CClaremout Business Park 2 Filing No. 1). 3

STREET IMPROVEMENT PLANS

APRIL 2020

EL PASO COUNTY FILE NO. SF-20-0014

File: Q:\44037A-CBP F2-Lots 1-8\44037A-CBP F2-Lots 1-8.dwg Const Dwg\STREET AND STORM\S03.dwg Plotstamp: 10/21/2020 10:58 AM

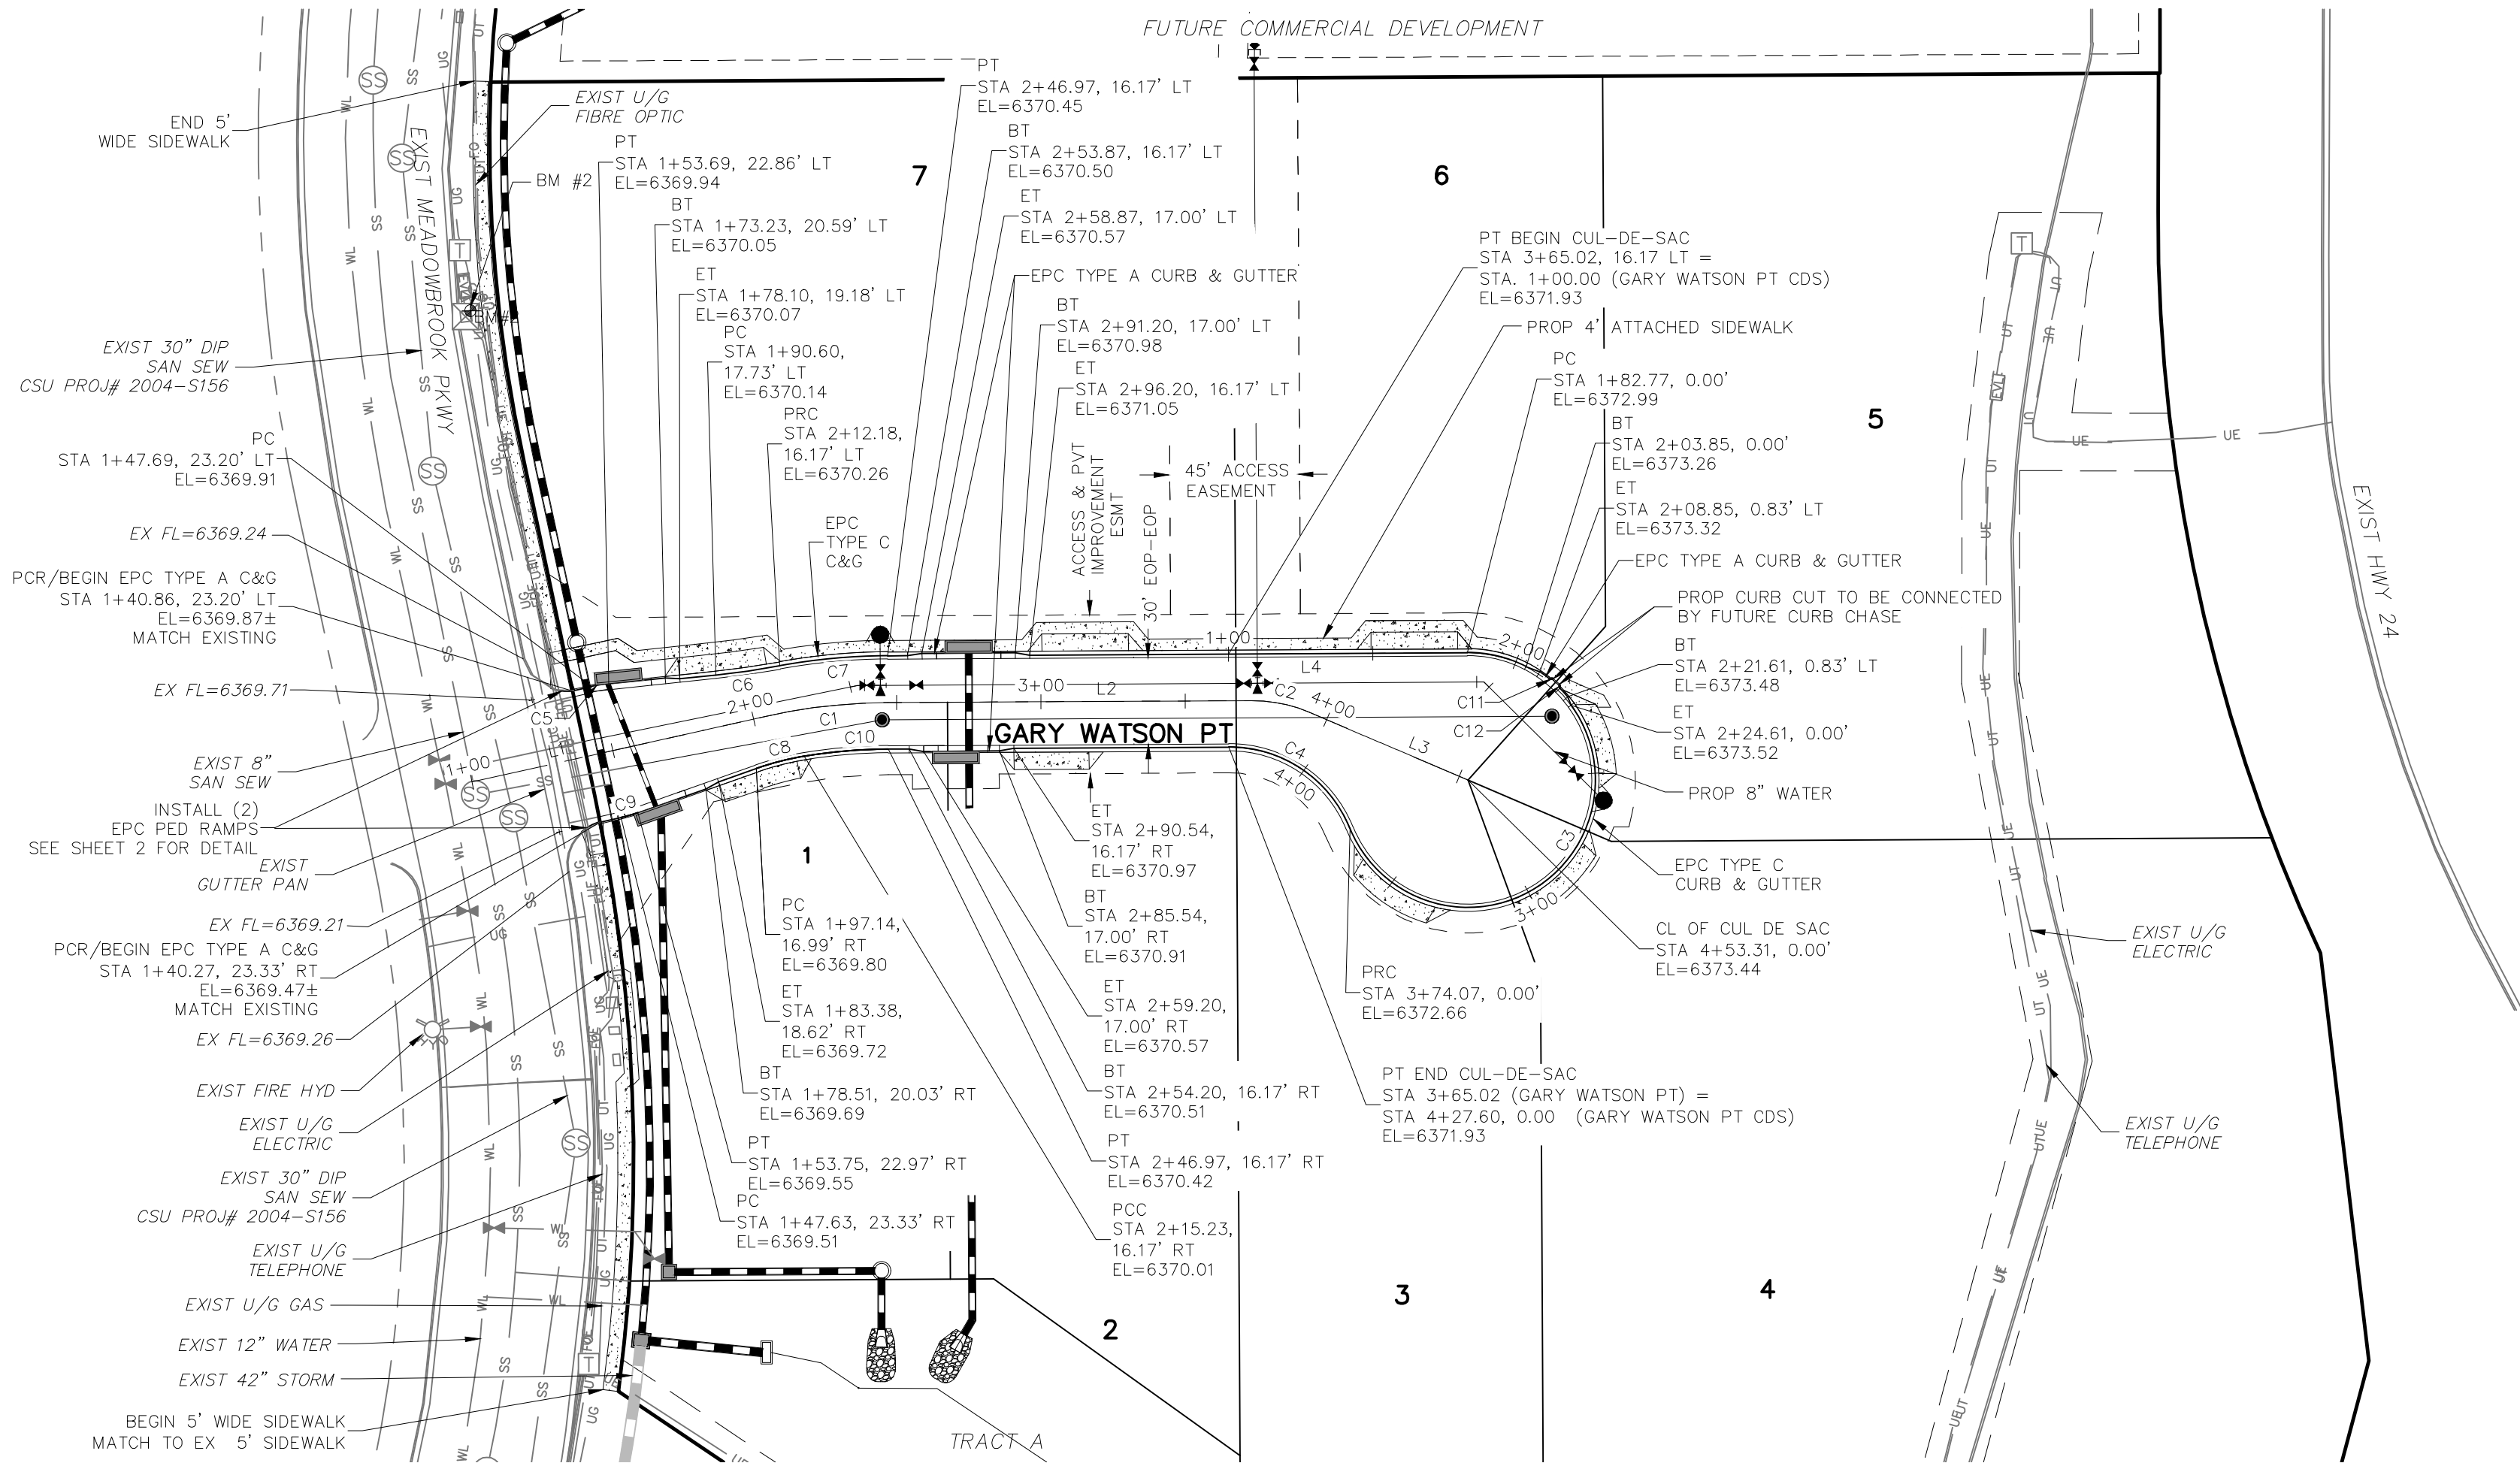
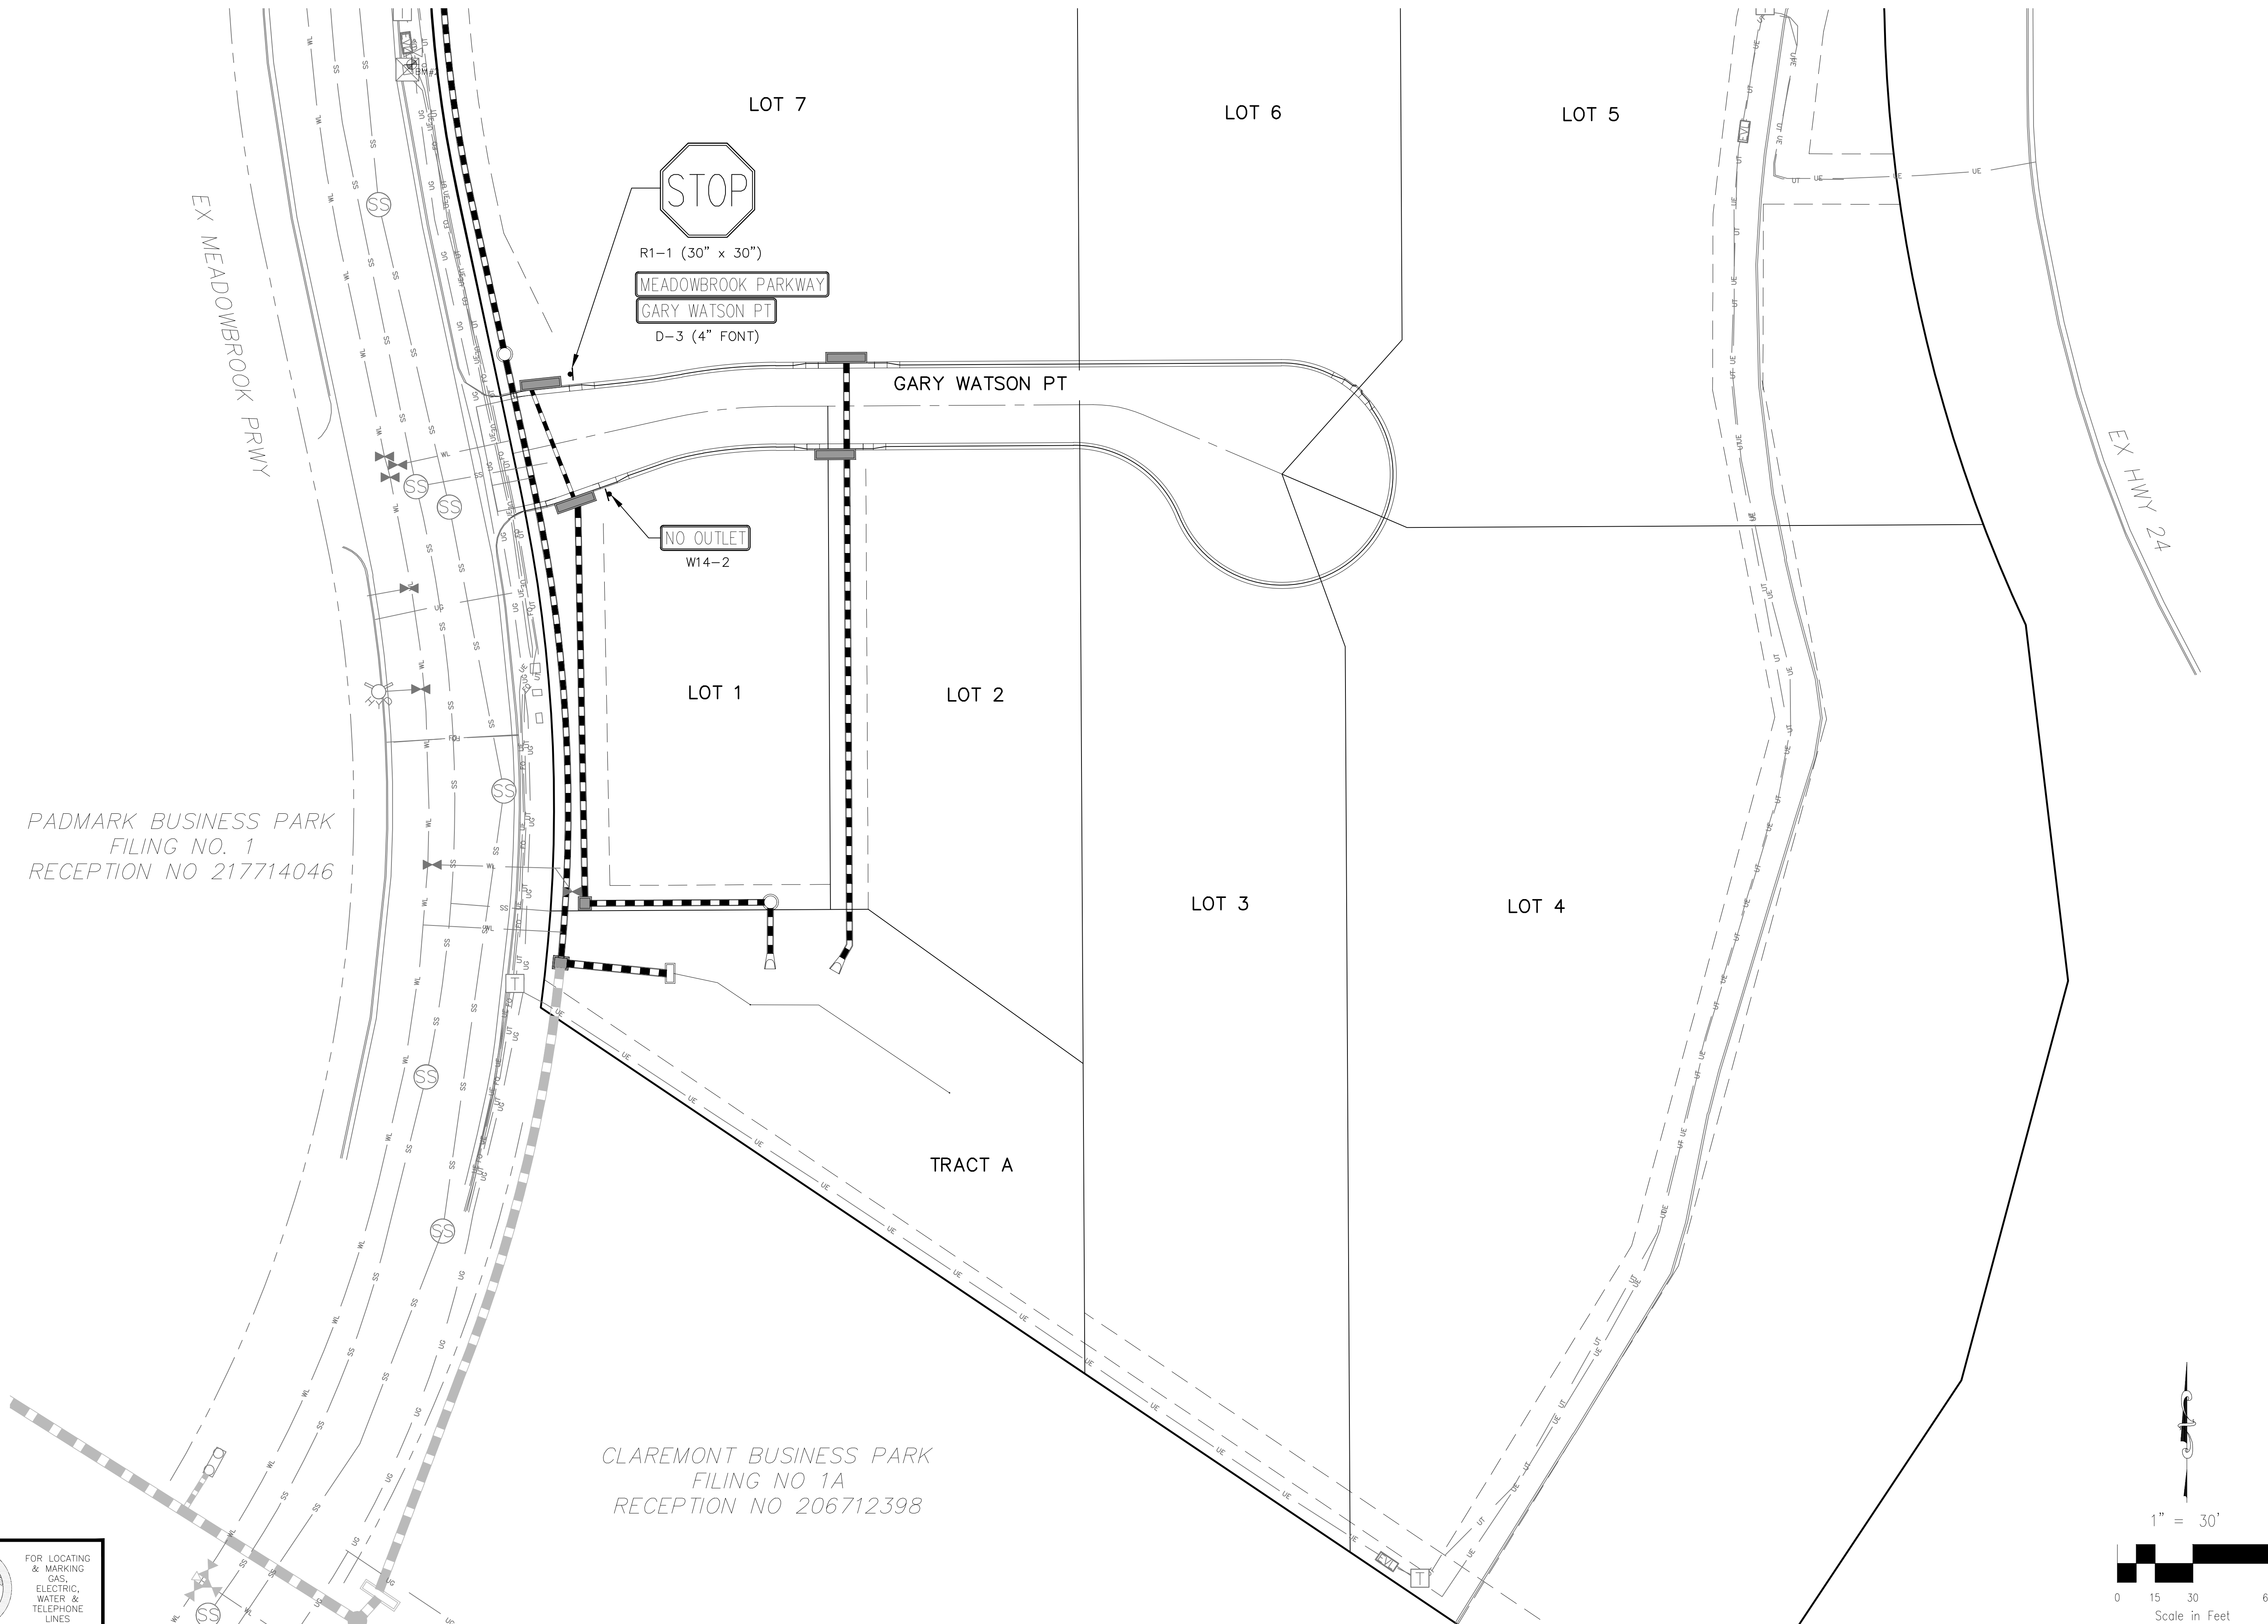
Provide sidewalk at the north side of the private road as discussed in the conference call with staff.
